**Consultation Response from KC,
Trees**

2025/91185 building at, Back Chapel Lane, Moldgreen, Huddersfield, HD5 9BG

Demolition of redundant engineering building and erection of student accommodation block

Date Responded: 19/06/2025

**1** PROP. SITE PLAN  
 1 : 200

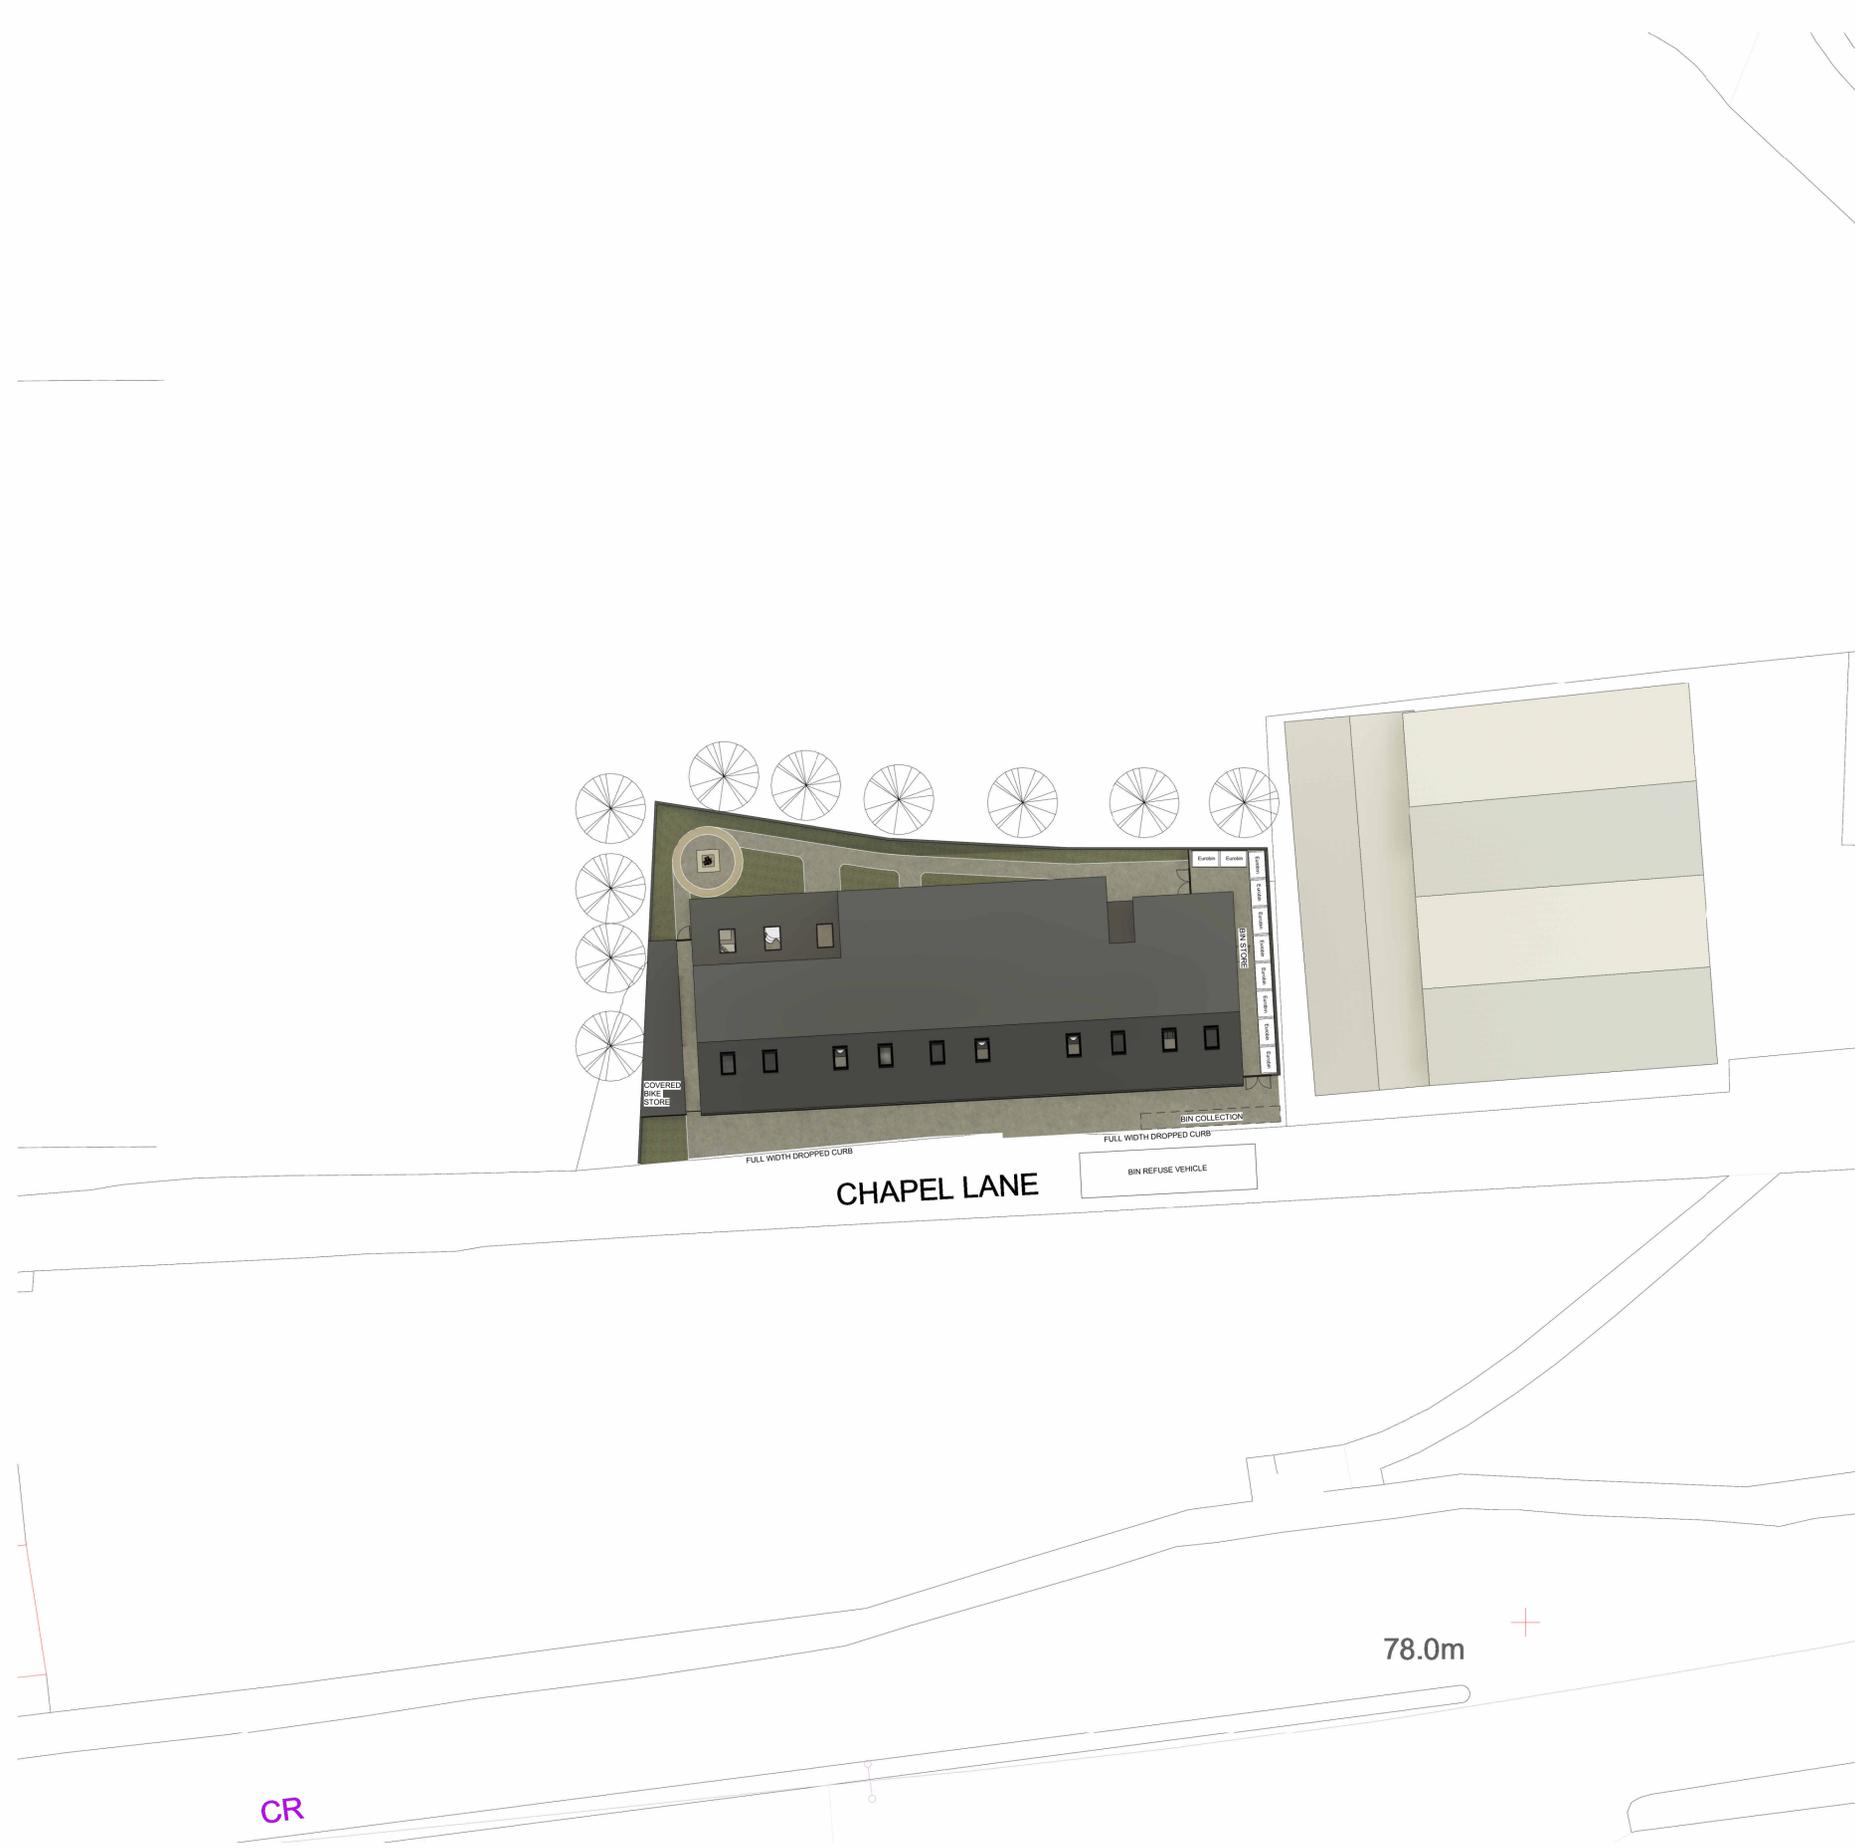
There are no protected trees on or adjacent the site.

The current proposals suggest the removal of trees within the northwest corner of the site and a small amount from the northern boundary, whilst retaining G2. These are all fairly young, self-set, category C trees and their removal is acceptable to facilitate the development. G2 should be retained as these are higher value trees which would add to the setting of the new development.

The proposals look achievable and there would be no objection from the Trees team.
